Thomas FitzGerald - Online Submission from Rosemary Vickery (object)

Name: Mrs Rosemary Vickery
 Address: 6 Lovat Brae Court
 Banora Point
 NSW 2486
 Name of Application: Residential Subdivision at Fraser Drive, Terranora
 Application Number: (09_0166)

Action: I object to the project.

PERSPECTIVE OF LANDSCAPE BUFFER & SCREENING TO FRASER DRIVE.  
 (SOURCE: TWEED HEADS SHIRE COUNCIL, DCP, 2011)

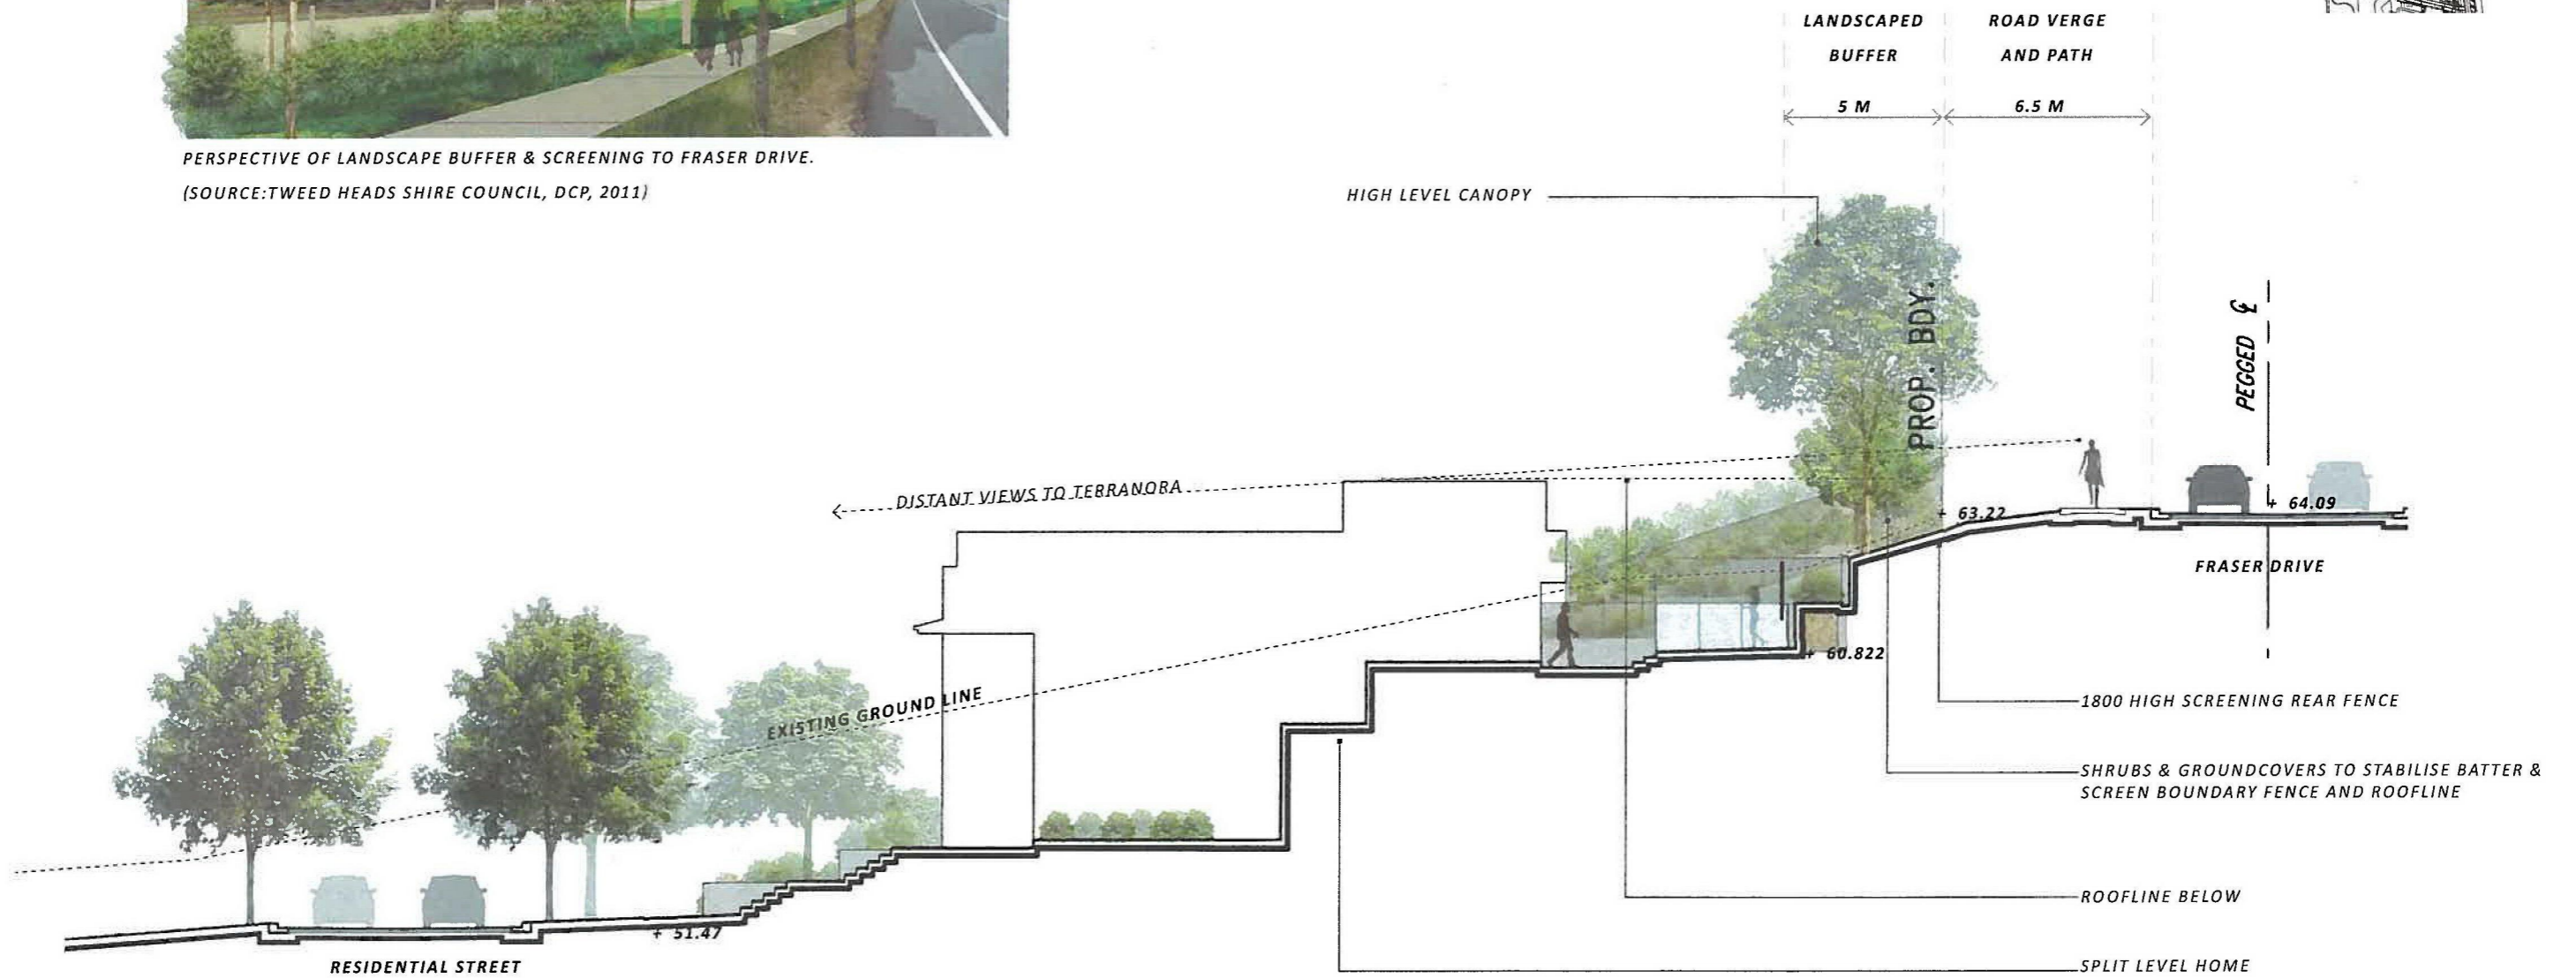
3. The erection of the 2.4 metre fence will block the view of residents along Fraser Drive to the Terranora Lakes and rural setting that was a key reason for purchasing and/or building homes along Fraser Drive. To look out on to a fence is not aesthetically pleasing, nor will it be an attractive feature to potential buyers when present property owners on Fraser Drive attempt to sell their properties.

4. The erection of the 2.4 metre acoustic fence on Fraser Drive will block the view of all on Fraser Drive, both living in their homes and those driving on Fraser Drive. At present Fraser Drive has a beautiful vista. The erection of a 2.4 metre fence along its proposed length does not benefit the residents including myself, who currently enjoy the view.

ELEVATIONS 1:100

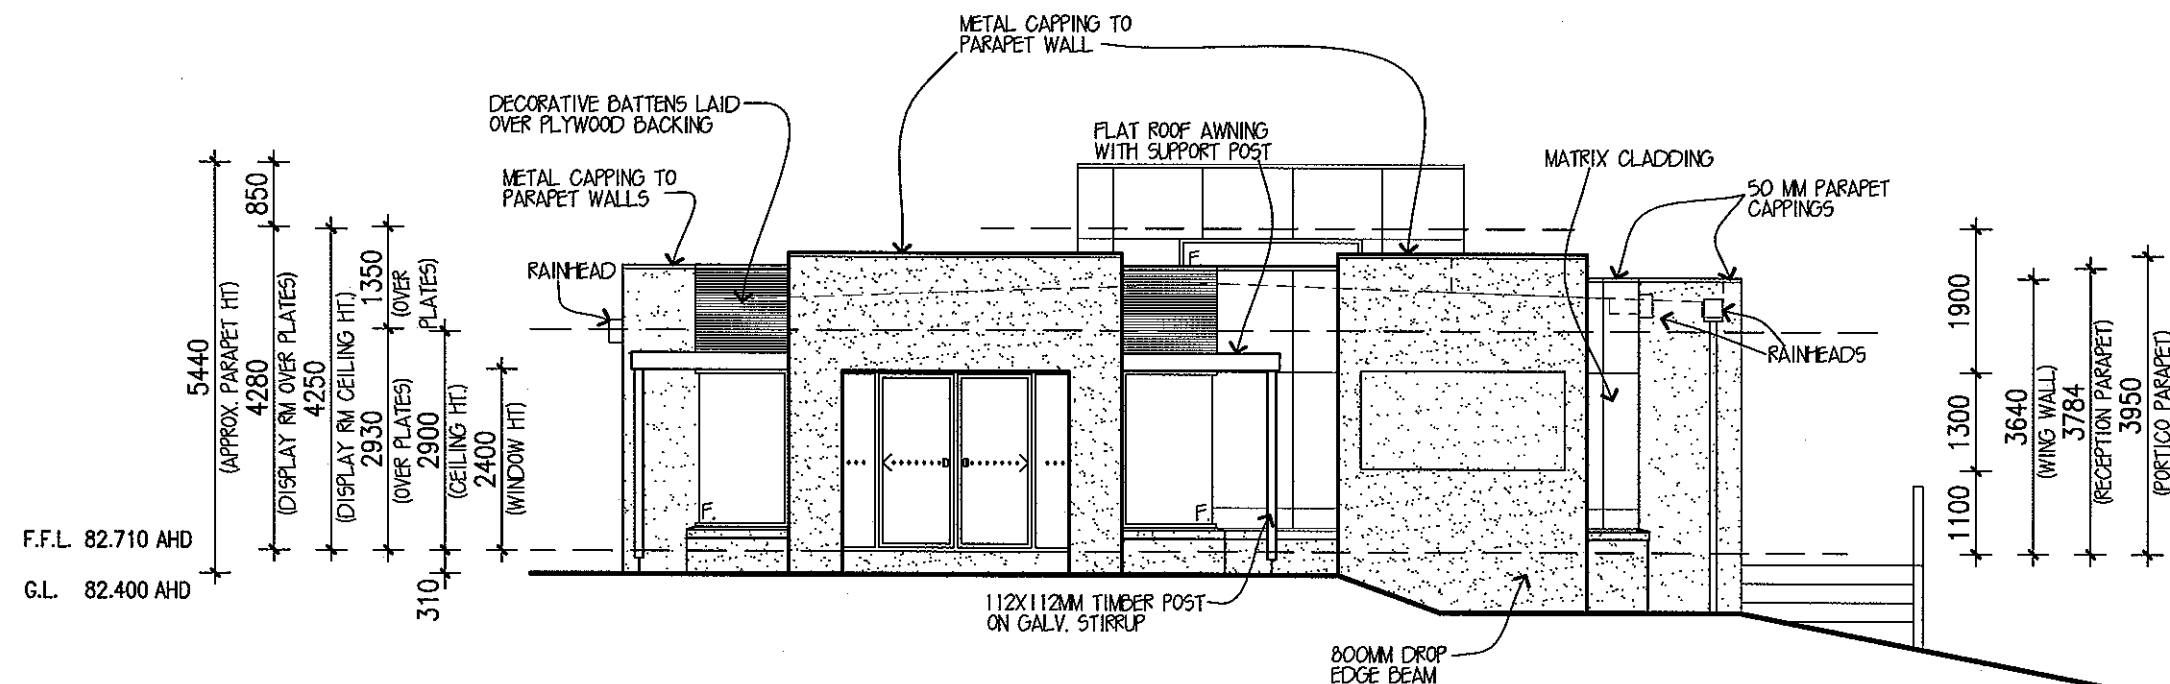
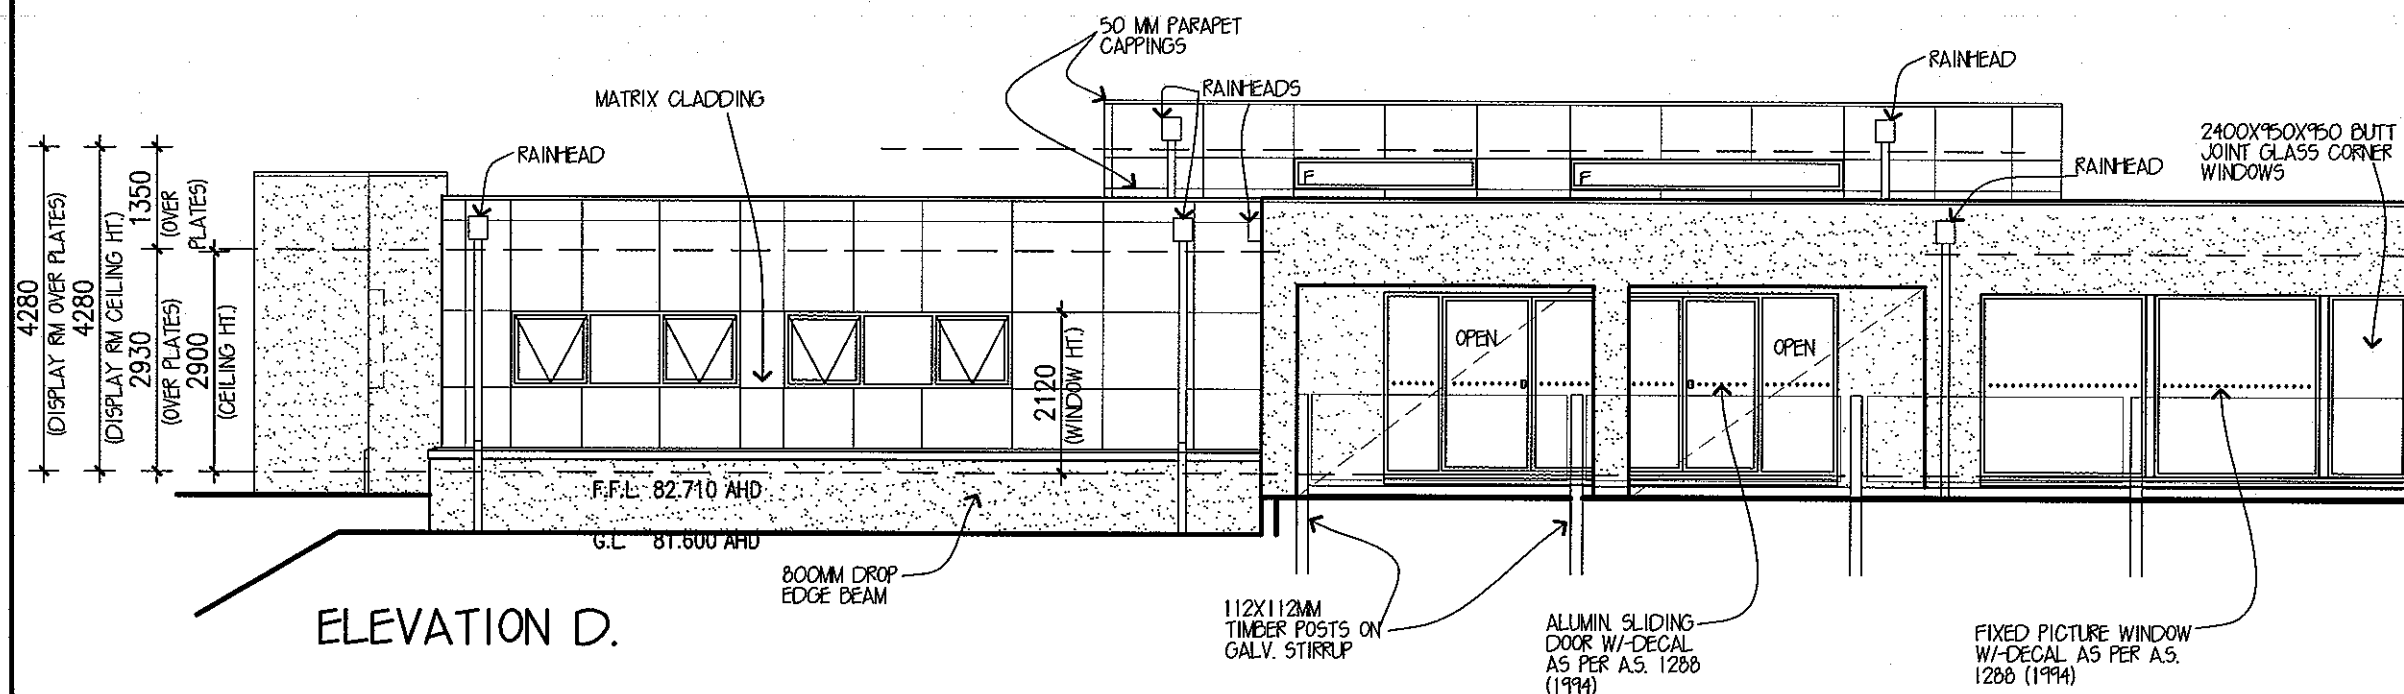
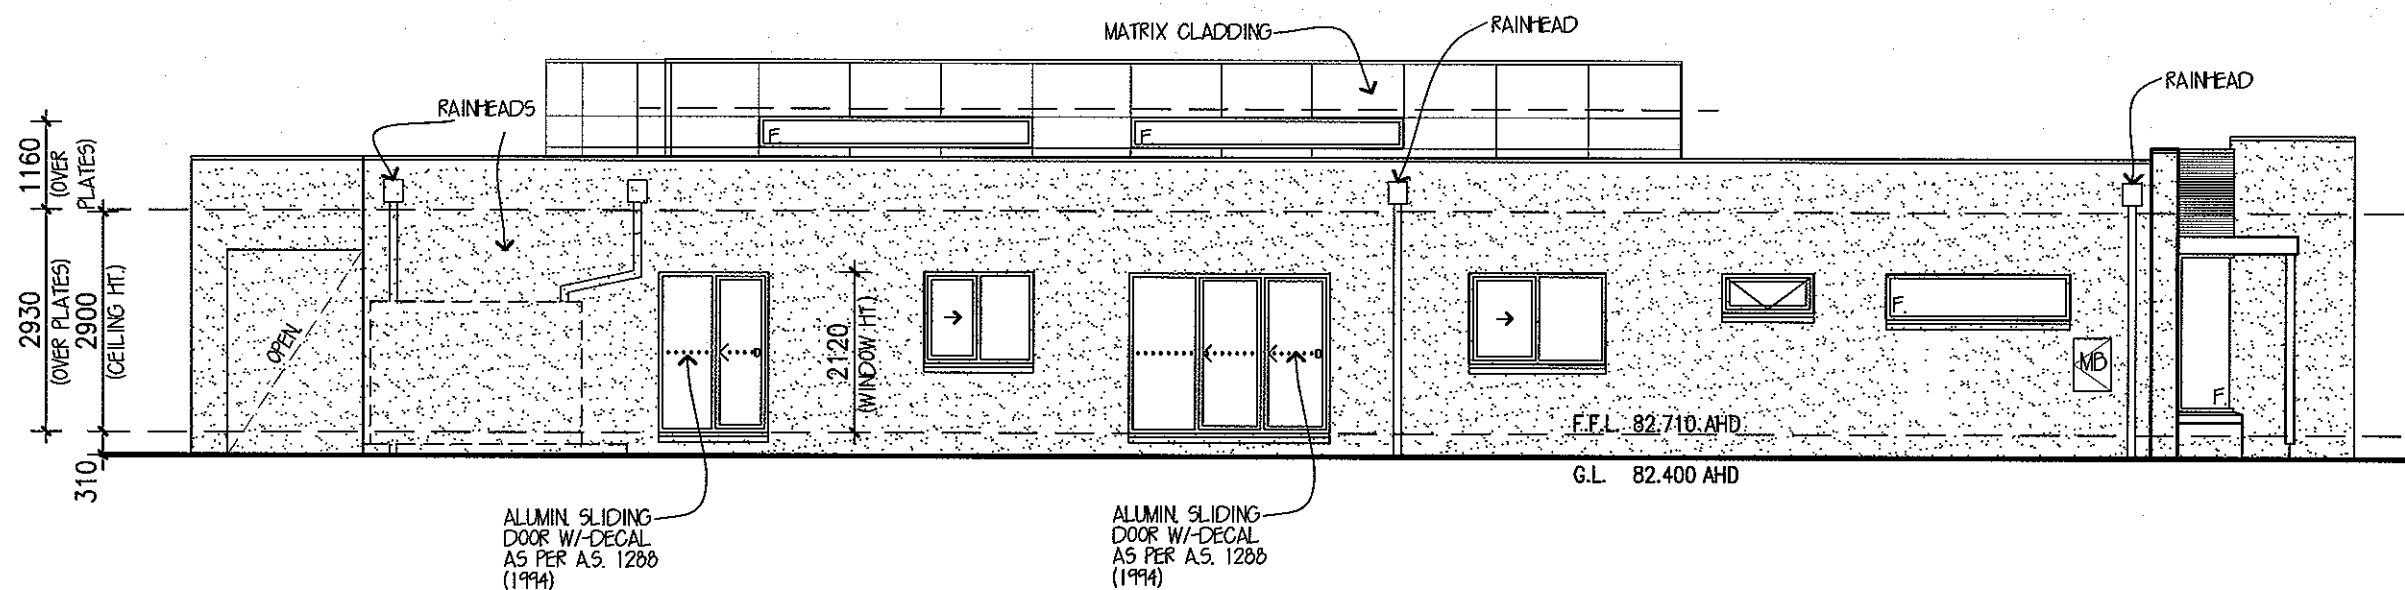
7. Proposed house designs of the residential development show no eave overhangs. This may allow Newland to cram more houses on smaller allotments but gives no consideration to the protection that eave overhangs give to thermal and weather protection of windows and walls in this climate. Houses without eaves will need to be air-conditioned which is a huge environmental and financial imposition for the future owners and the community.
